# KITTITAS COUNTY

## DEPARTMENT OF PUBLIC WORKS

### MEMORANDUM

**TO:** All Staff  
**FROM:** Public Works Plan Review Team  
**DATE:** February 5<sup>th</sup>, 2024  
**SUBJECT:** SX-24-00001 Baumann

UNIFIED SITE PLAN
10350 MANASTASH ROAD, ELLENSBURG
 WITHIN THE E1/2 OF THE NW1/4 OF SECTION 15, TOWNSHIP 17 NORTH, RANGE 17 EAST, W.M., KITTITAS COUNTY, WASHINGTON

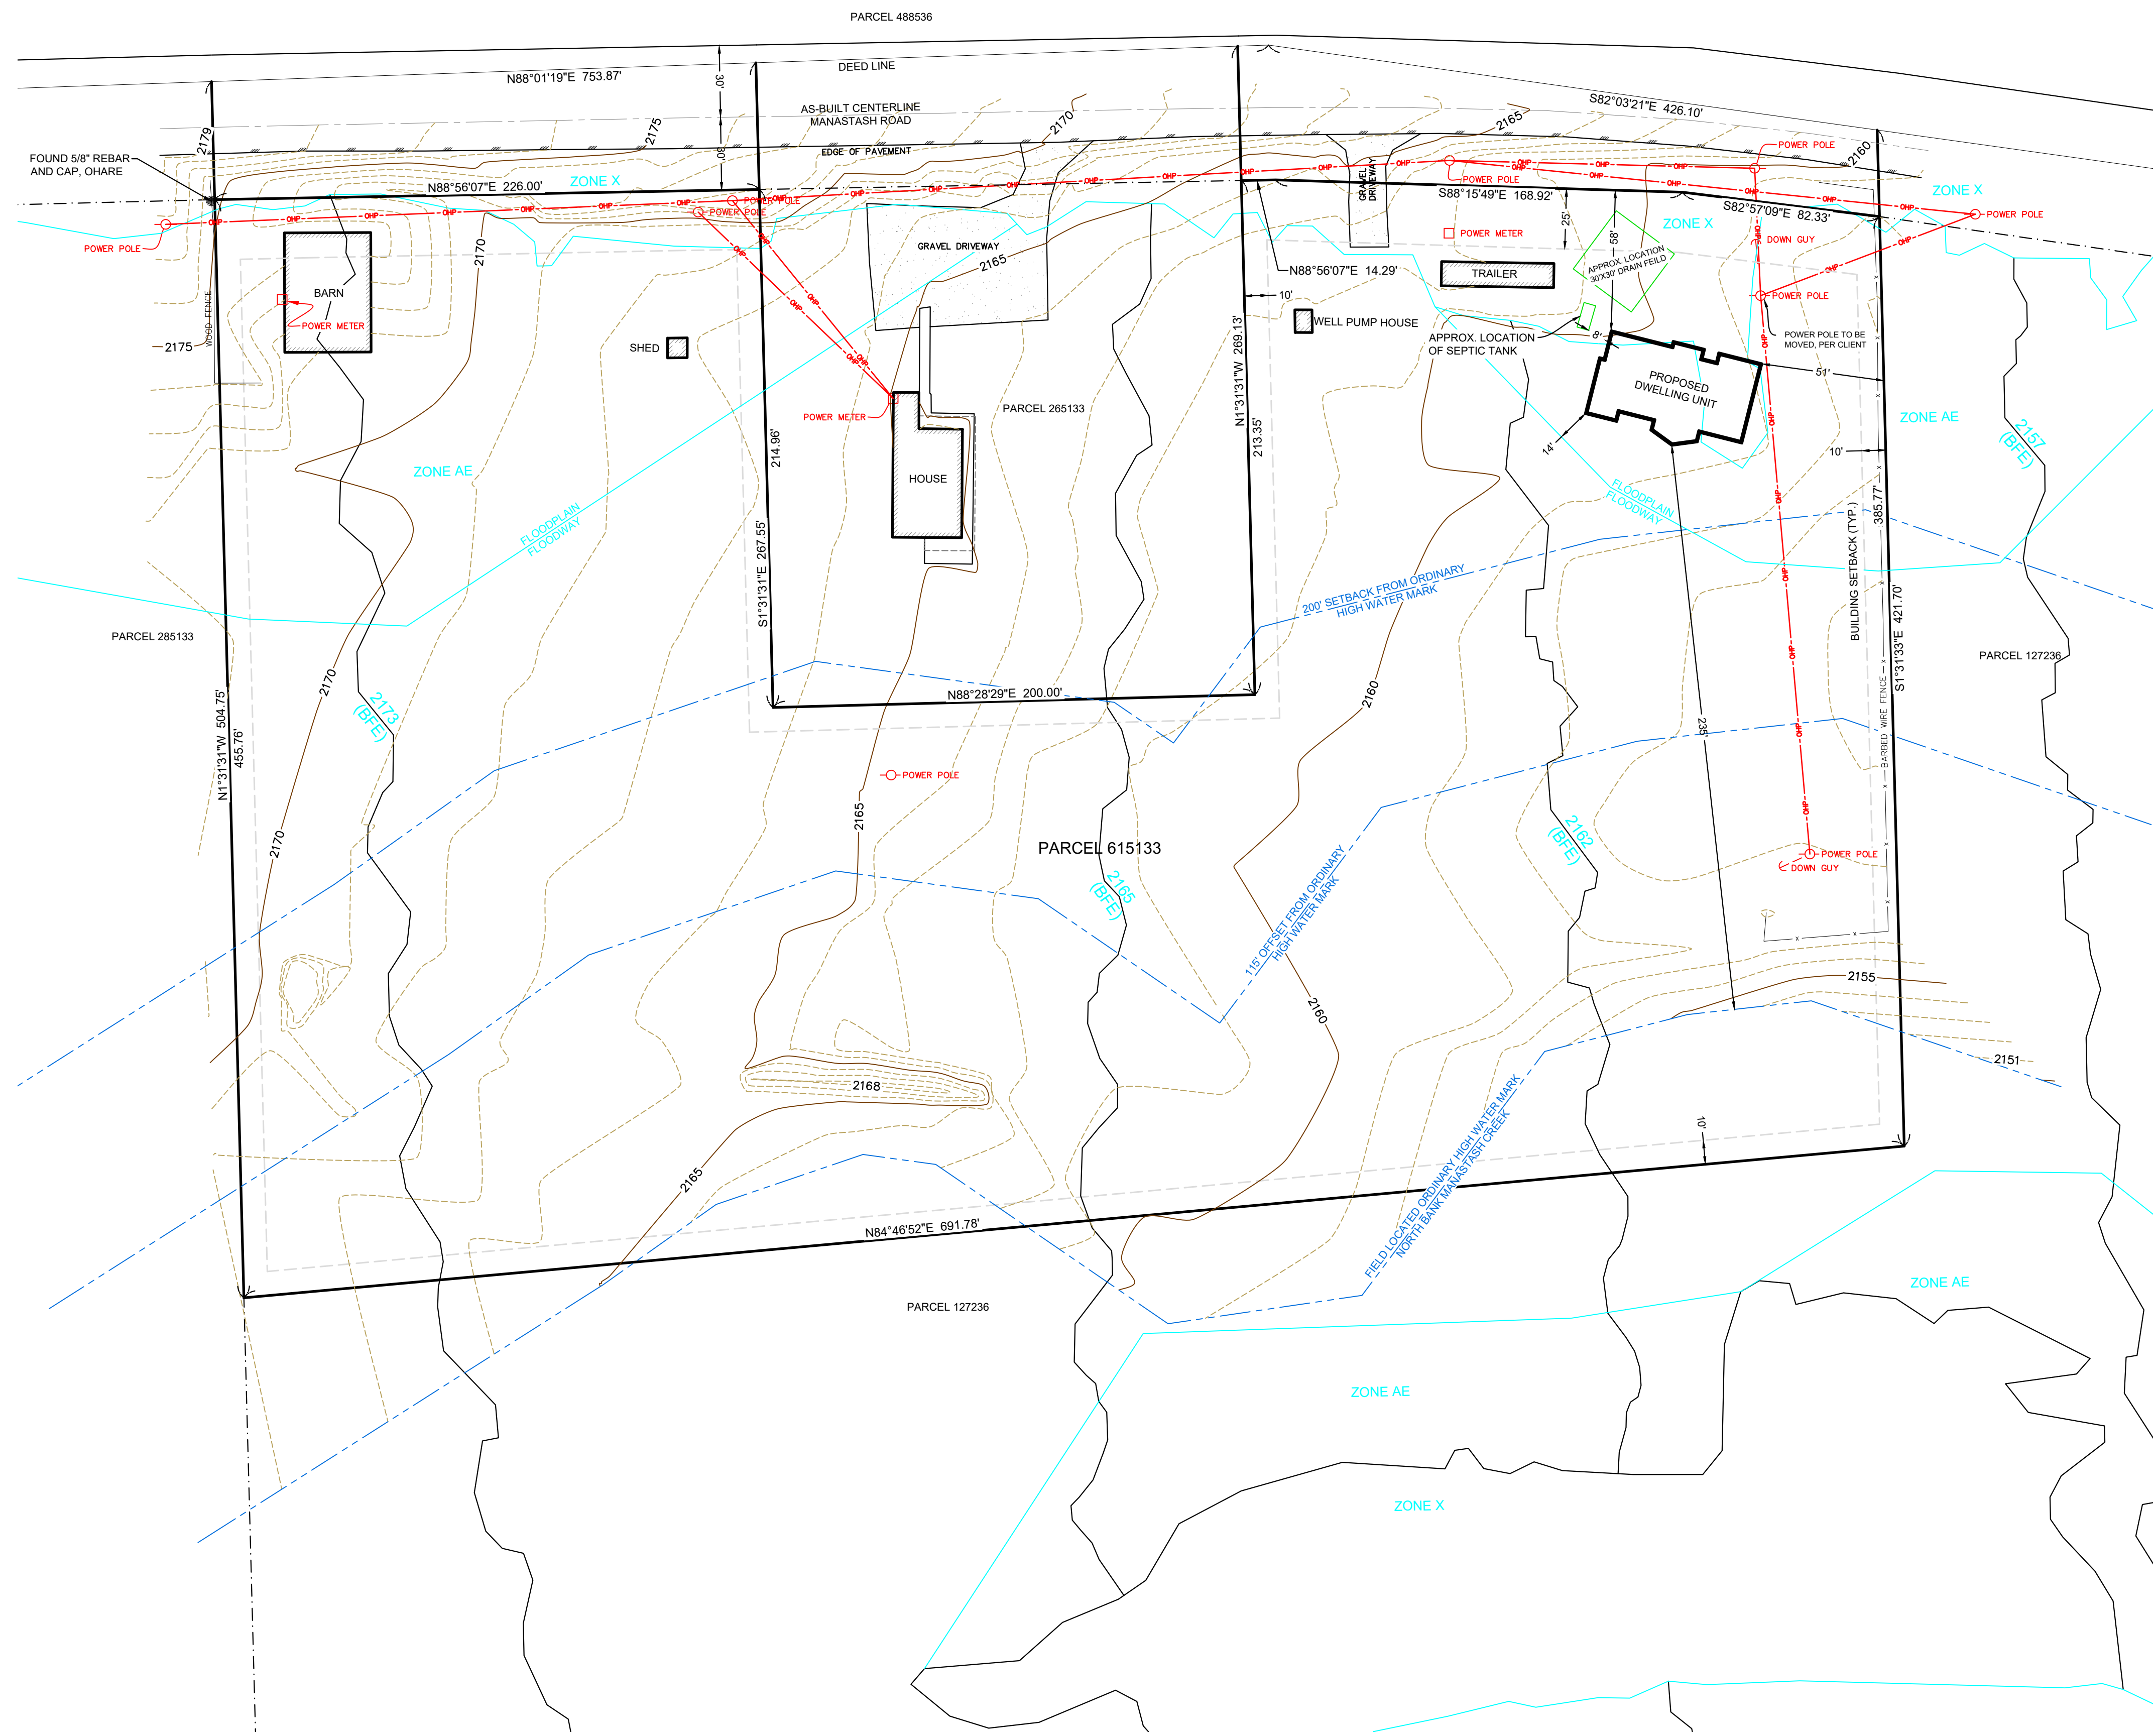
<b>ENGINEERING</b>	Except as exempted in Section KCC 14.05.060 no grading or filling upon a site involving more than one hundred (100) cubic yards shall be performed without a grading permit from the County Engineer or Public Works designee (KCC 14.05.050). An application for grading in excess of five hundred (500) cubic yards shall be accompanied by an engineered grading plan (KCC 14.05.080).
<b>FLOOD</b>	<p>The proposed development requires a floodplain development permit and must meet KCC 14.08 requirements. Public Works has received a floodplain development application for the project that is under review.</p> <p>The parcel contains FEMA designated Floodway. Per the submitted site plan, the proposed single-family residence is located outside the Floodway. Please be advised that the Floodway is highly restricted and any development within the floodway must be permitted through a floodplain development permit and must demonstrate no rise of 100-year flood elevations before being permitted. No new or substantially improved residences are allowed within the Floodway. (SC)</p>
